*To Protect and Promote the Health and the Environment of the People of Kittitas County*

RE: B. Proctor Short Plat SP-08-00058

B. PROCTOR SHORT PLAT
A PORTION OF THE SE 1/4 OF SEC. 12, T2N, 17N, R9E, 19E, W.M.
KITTITAS COUNTY, WASHINGTON

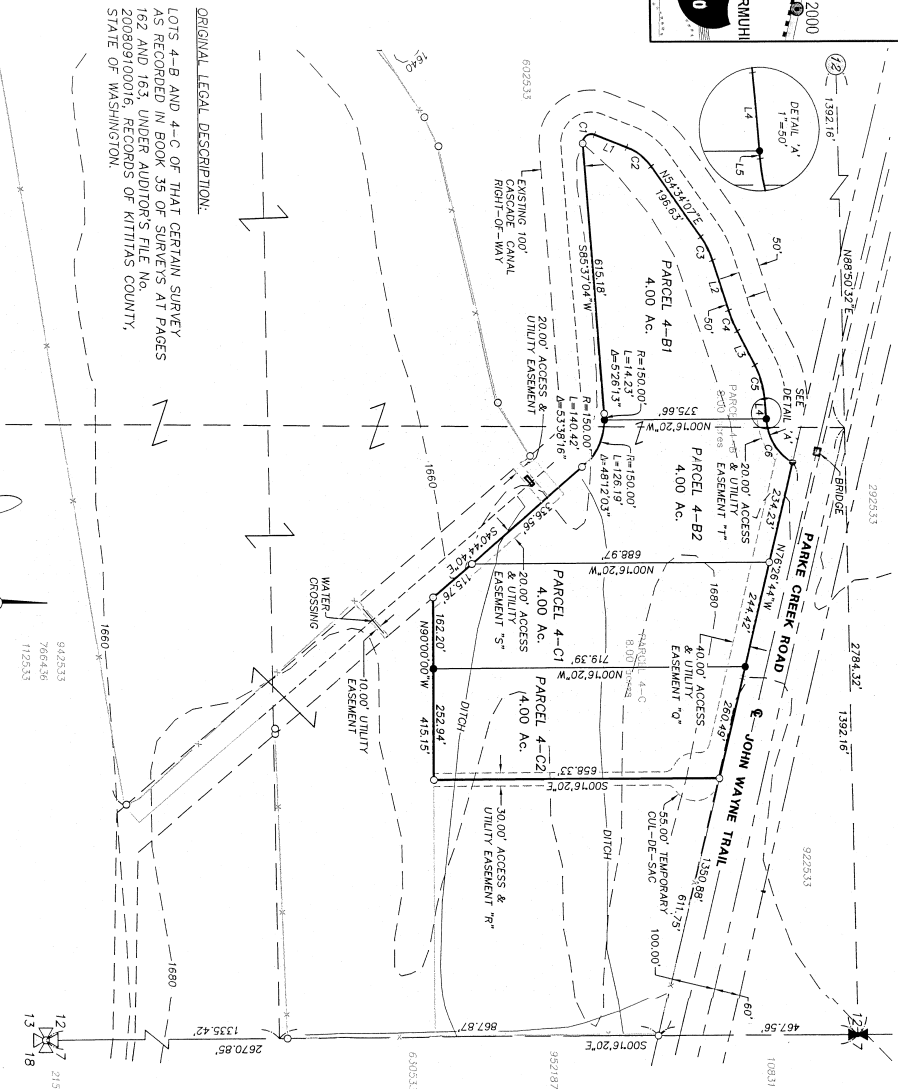
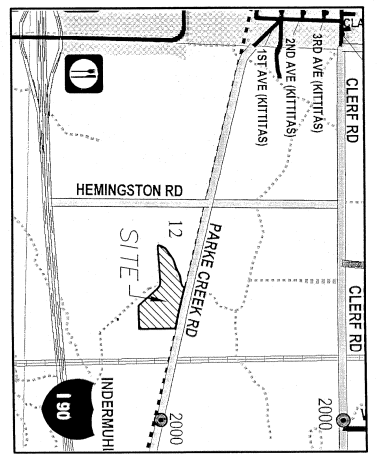
The final plat notes shall include the following two statements:

*"The approval of this division of land includes no guarantee that there is a legal right to withdraw groundwater within the land division. The approval of this division of land provides no guarantee that use of water under the ground water exemption (RCW 90.44.050) for this plat or any portion thereof will not be subject to curtailment by the Department of Ecology or a court of law. "*

*"Metering will be required on all new residential well connections and metering results shall be recorded in a manner consistent with Kittitas County and Washington State Department of Ecology requirements."*
